WEST SUSSEX COUNTY COUNCIL
STRATEGIC PLANNING CONSULTATION

DATE: 14th March 2017

SUBJECT: LU/182/15/PL - Variation of conditions 4, 6, 7, 8, 39 and 42 imposed under planning reference LU/47/11/ relating to list of plans, illustrative masterplan, CHP plant building, Design Statement, bus stops & traffic improvements.

LOCATION: Land North of Toddington Lane, Littlehampton, BN17 7PP.

Rev	-	-	-	-	-
Date	27.06.16				
Scale	1:2500 @ A1				
Orig No	519-GR.L_010				
Drawing Title: Parameter Plan - Vehicular Access					
Drawing Status: SUBMITTED					
Drawn: KJ					
Rev: -

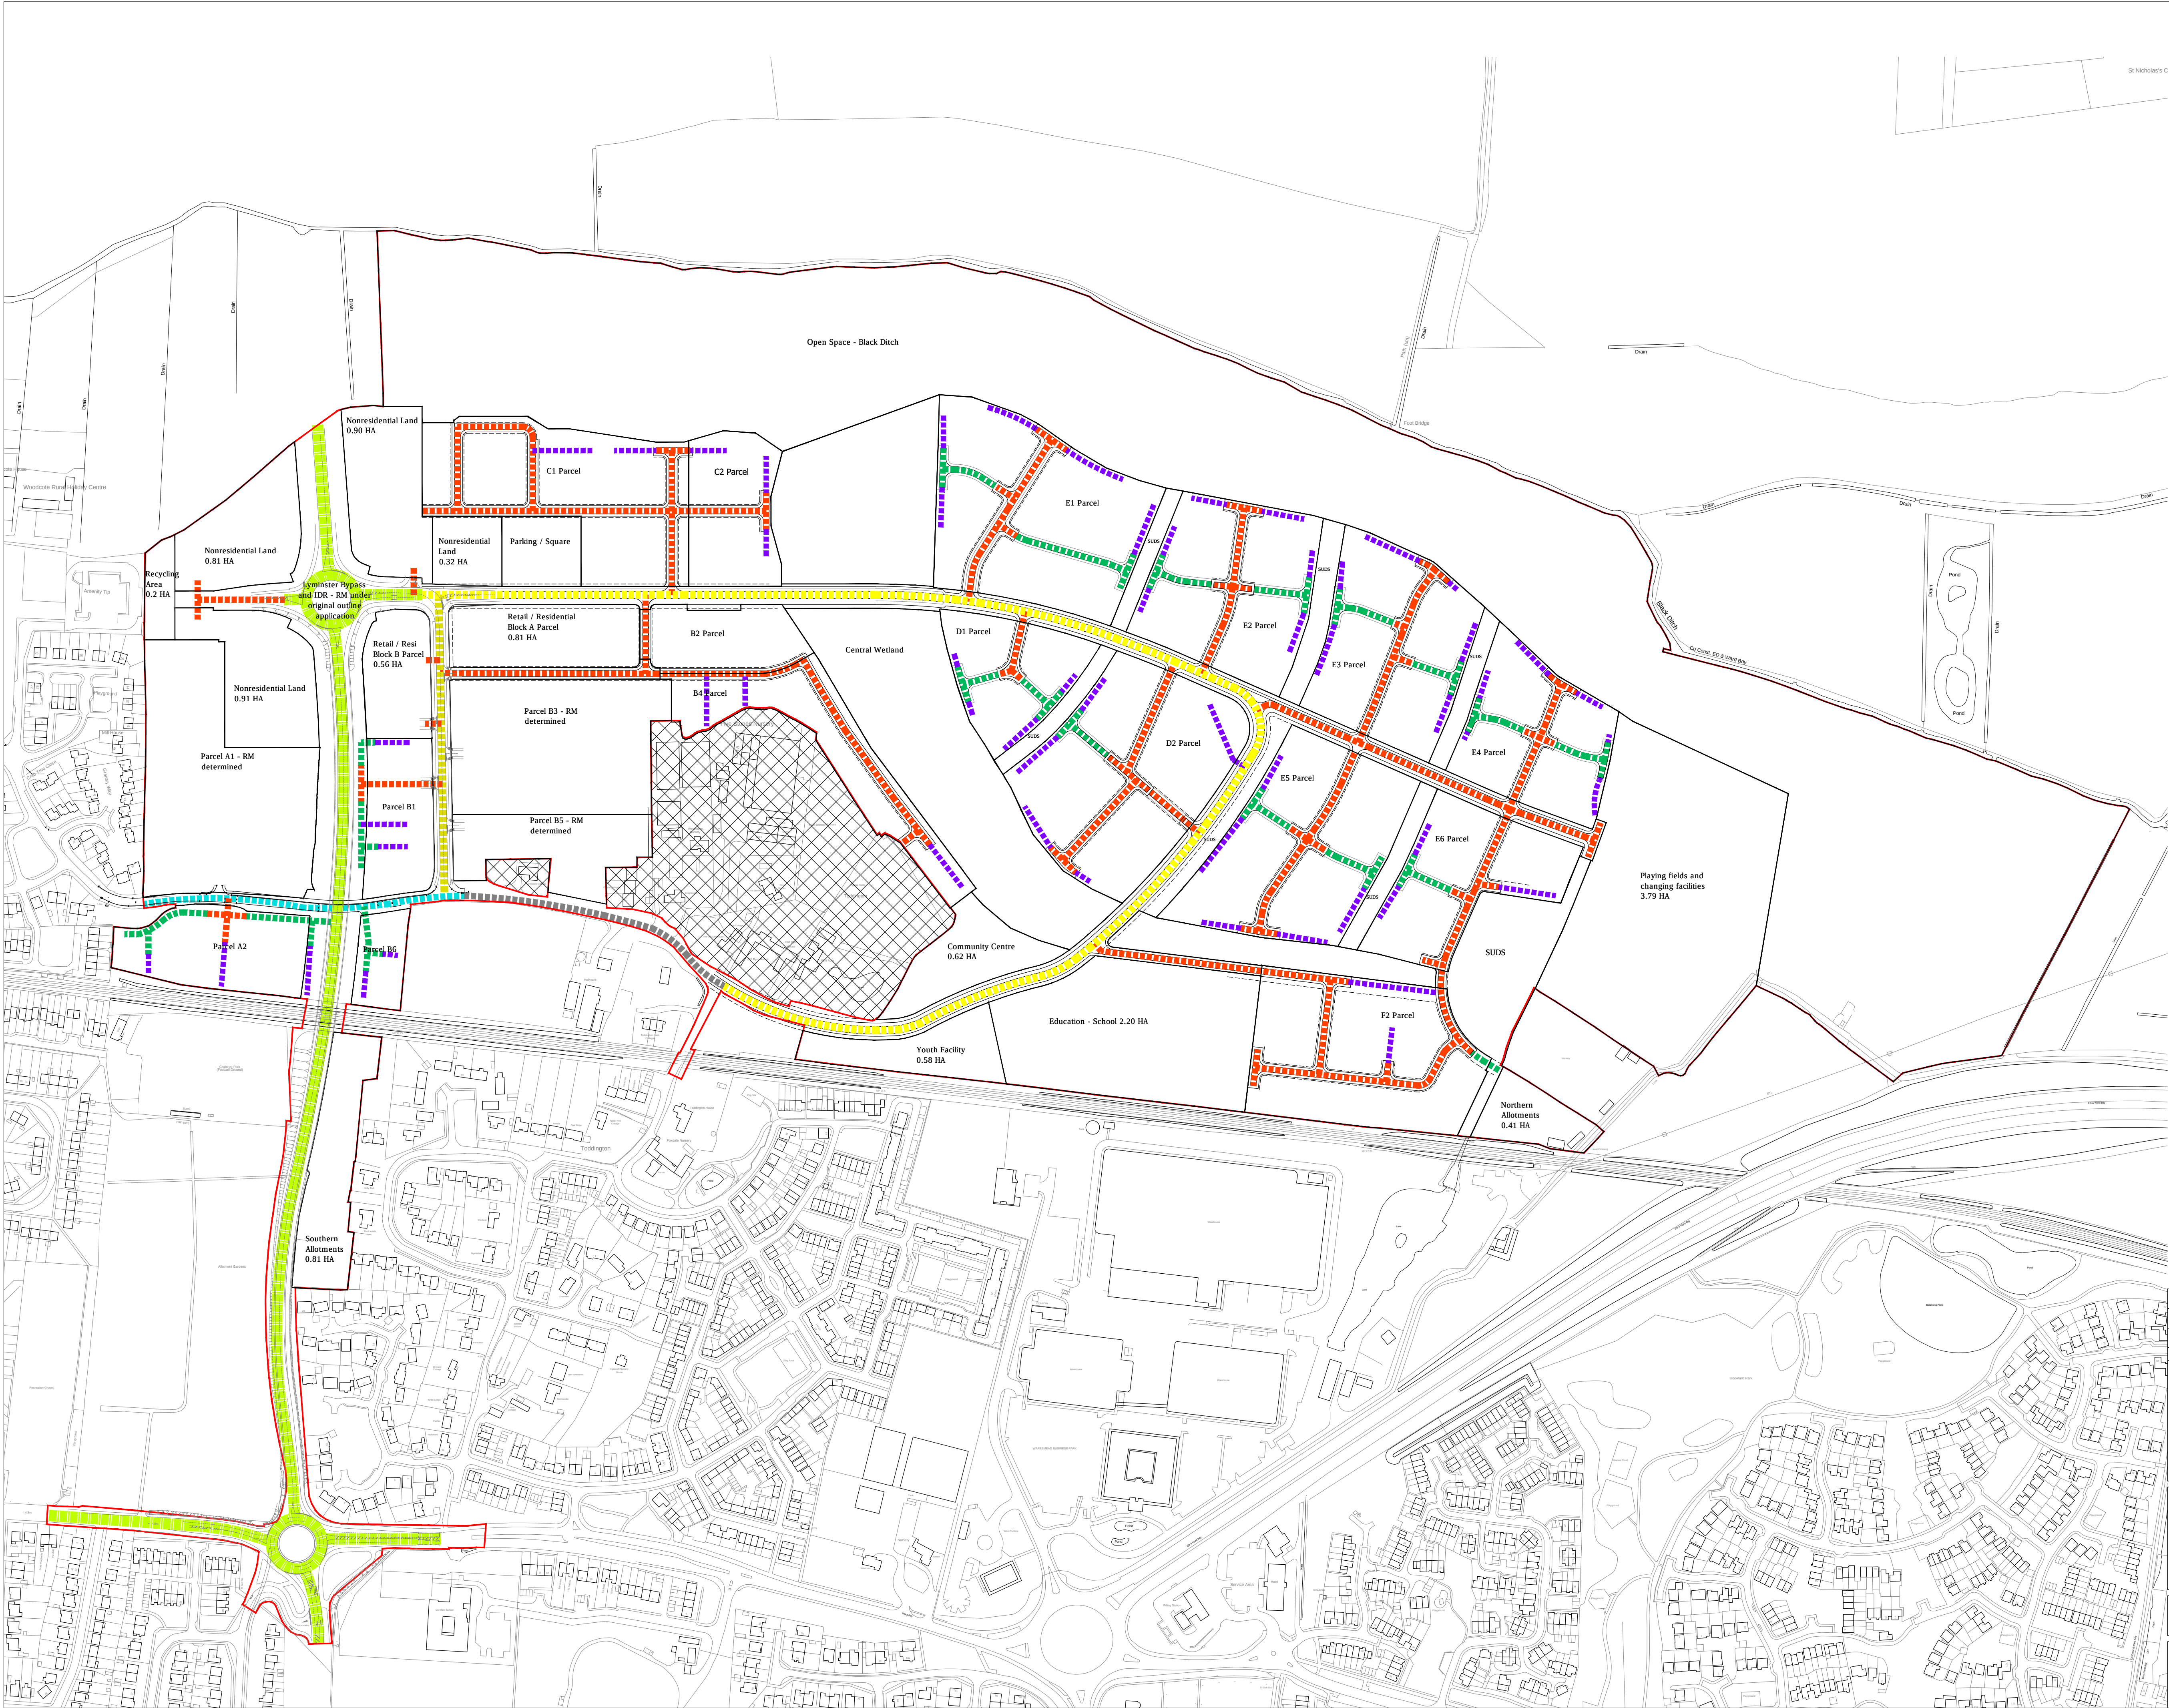
3. **Condition 7** (appearance, landscaping and layout particulars to be approved) – Comments as follows:
- Road widths (residential access roads – **NOT** Strategic Roads nor loop/spine road) – Minimum road width shall be 4.8m. For reasons of safety and accessibility, 4.1m wide roads/access drives (as quoted in the Development Framework Document) should not be provided. Only private drives and shared drives are proposed to be 4.1m – is this unacceptable? For the reasons given above, 4.8m should be provided – including private drives and shared drives where they serve more than one property and documented as such in the Masterplan document.

- Extent of road adoption – WSCC will adopt roads in red as shown below given their strategic nature (blue line is existing adopted public highway): no comment required. **Noted.**

- *Speed controls for internal roads (and speed limits) (comments do **NOT** refer to Strategic Roads shown in red above other than IDR and associated connection)* – Although a 20mph speed limit is suggested in the Development Framework Document, actual speeds will be determined by final road design. Therefore, it should not be assumed that 20mph road speeds will be achieved although that is what should be aimed for. Applicant should aim for this through careful design and associated speed controls. Particularly with regard to the main spine road ‘looping’ through the development, no evidence is shown of speed controls that will be necessary to manage traffic speeds. Appropriate junction treatments and other traffic management features for this road must be provided at appropriate locations. The onus will be on the applicant to demonstrate what and how traffic speeds will be managed on all roads proposed at the detailed design/reserved matters stages. As the spine/loop road is proposed to be a bus route, this should also be safety audited at the detailed designed/reserved matters stage. **Noted – matter for RMA. Noted.**

5. **Condition 39** (bus stops and associated infrastructure) – General reference is made to the location of bus stops and bus routing in the 'Development Framework Document' (December 2016). However, the actual detail is not. Although the principle of a route using the main spine road is accepted, the final detail can only be approved when detailed submissions are submitted to the LPA, CHA, Town Council and local bus company/ies for consideration. Any bus stops should, where possible or where required to be as specified in the S106 Agreement, be provided with bus shelters and real-time passenger information. **Noted.** Condition 39 will be discharged separately and should not be a consideration for this s73. Notwithstanding this an indicative bus stop plan will be provided as discussed with Claire Potts for information purposes only. **Noted.**

Site:	Date:
Toddington Lane Littlehampton	27.06.16
	Scale:
	1:2500 @ A1
	Orig No:
	519-GR.L_014
Drawing Title:	
Parameter Plan - Pedestrian and Cycle Access	
Drawing Status:	Drawn:
SUBMITTED	KJ / AT
	Rev:
	B

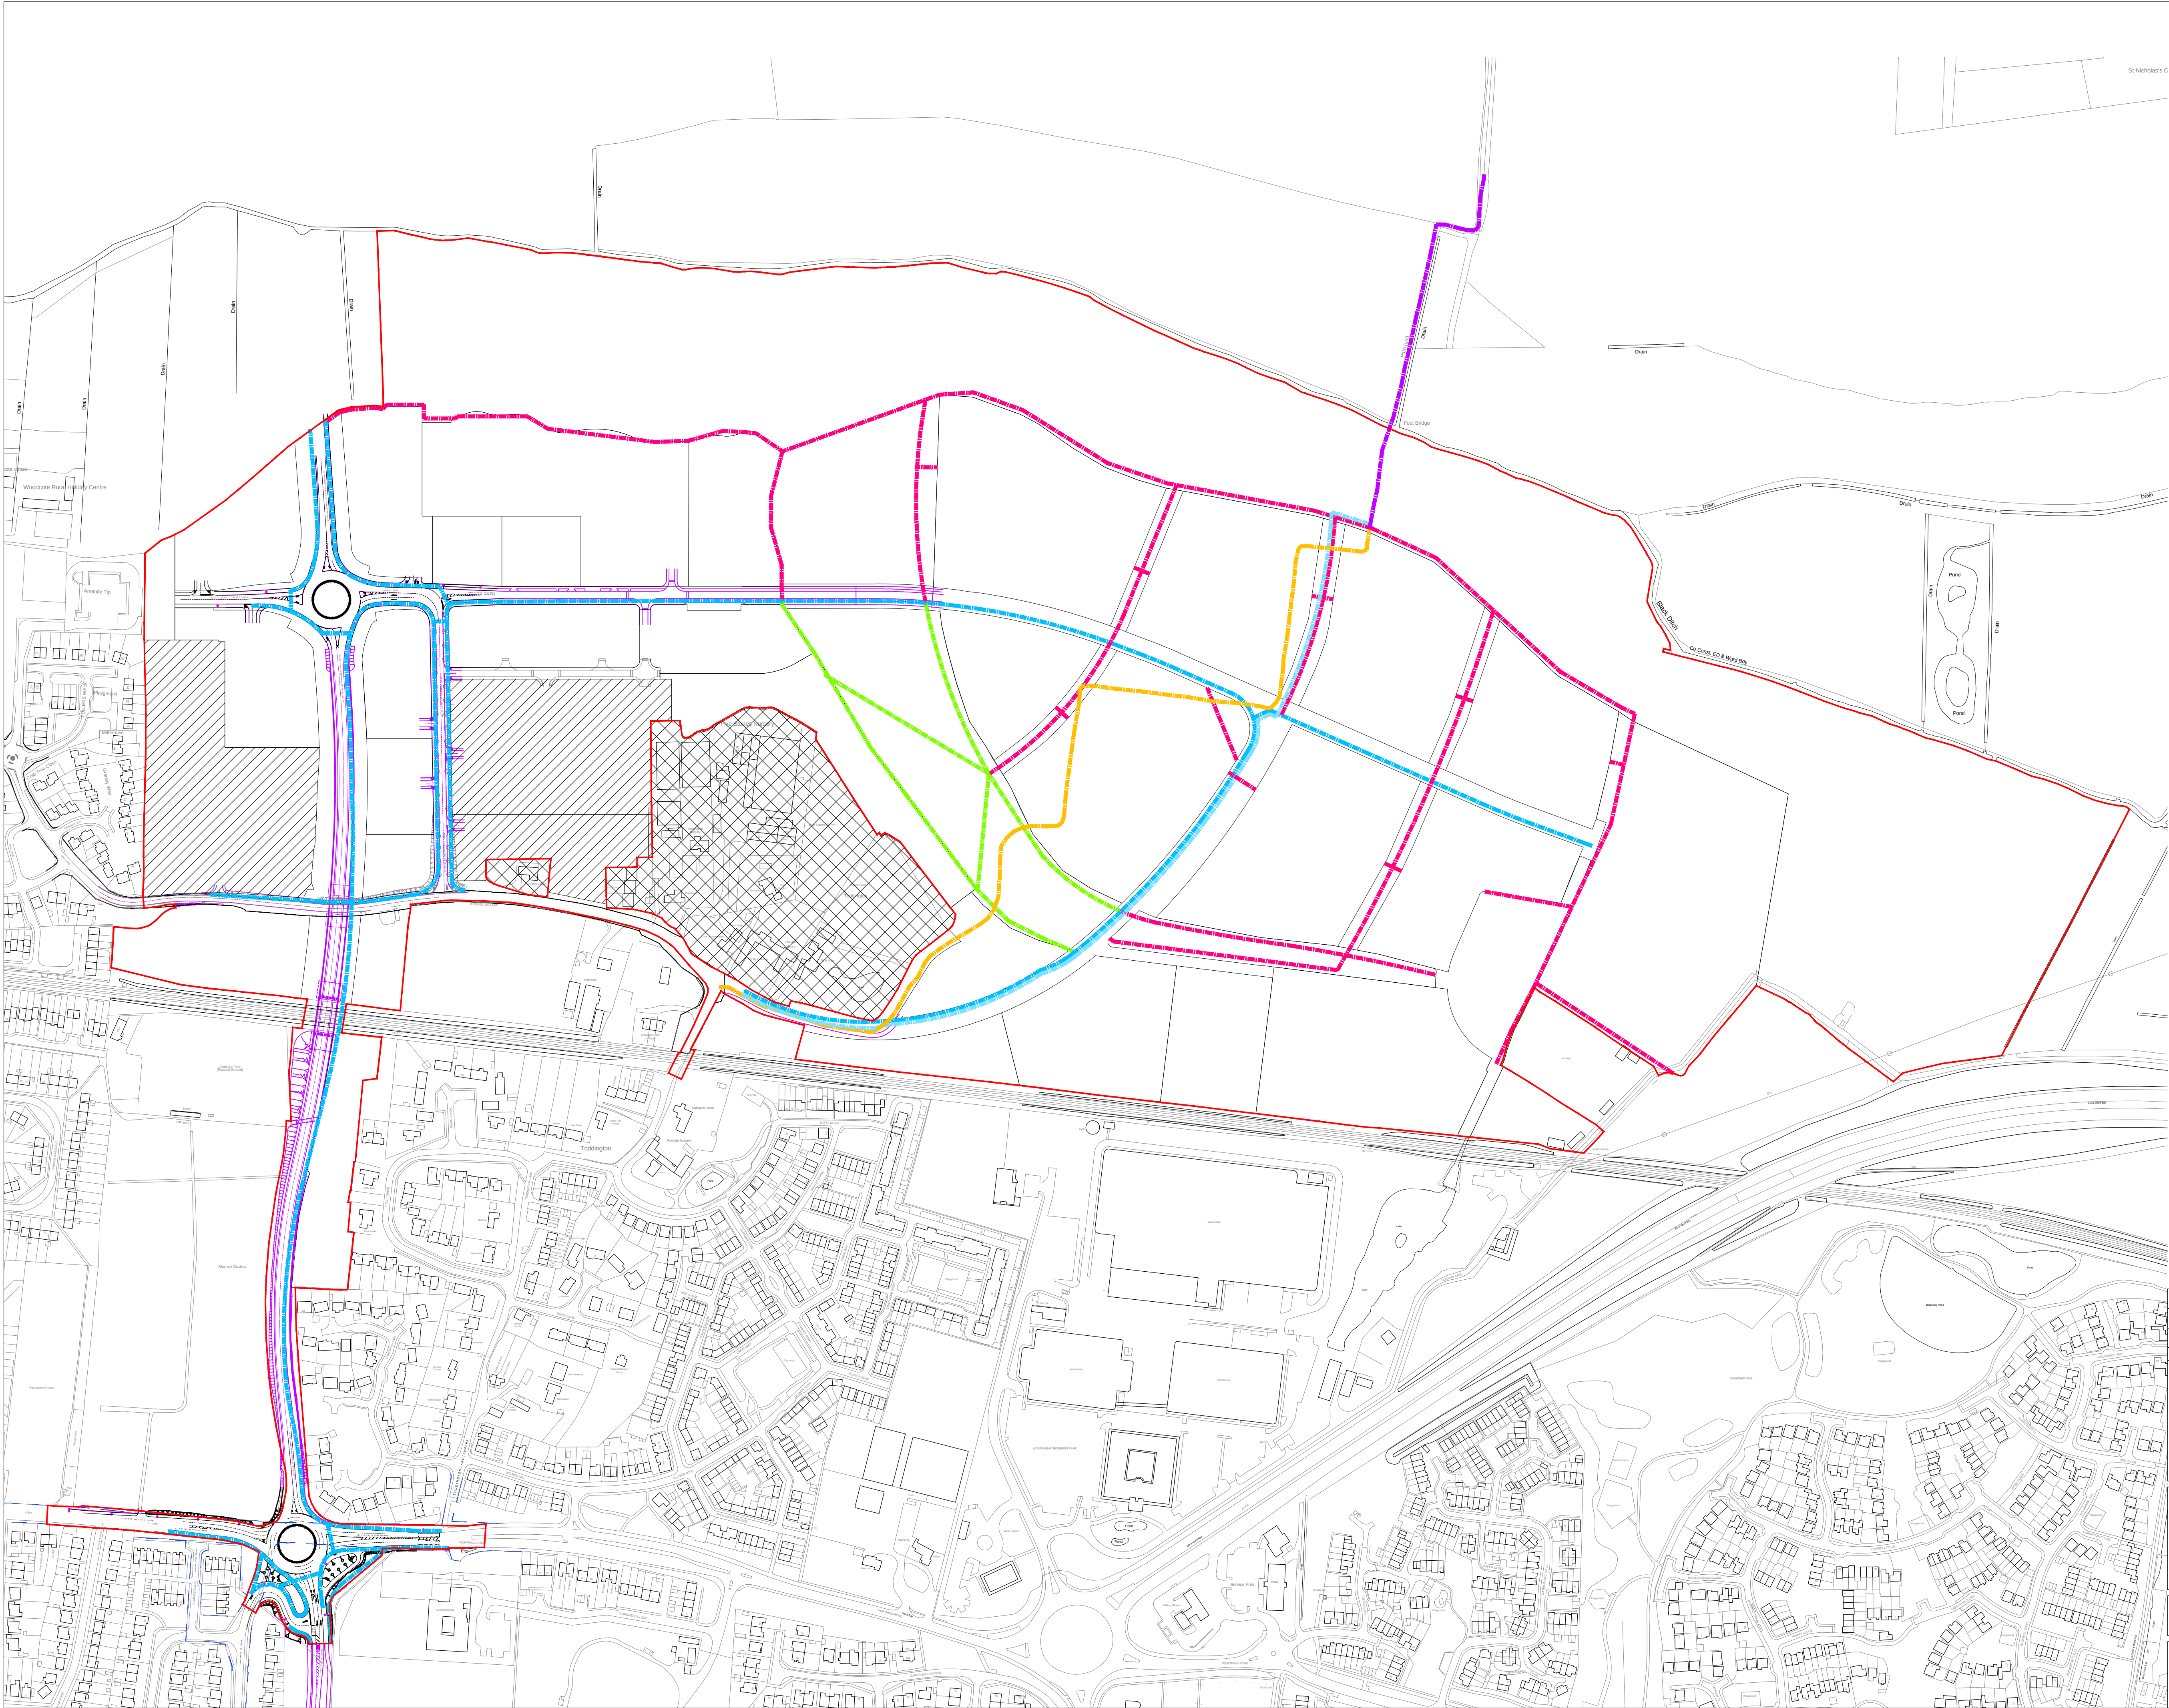
- *Cycleways (specifications)* – To accord with LTN 1/12 Para 7.60 and Table 7.4. **Please provide clarification of what document LTN 1/12 is?** The document is called: “Shared Use Routes for Pedestrians and Cyclists”. It is published by the Department for Transport and sets-out appropriate design criteria for such routes.
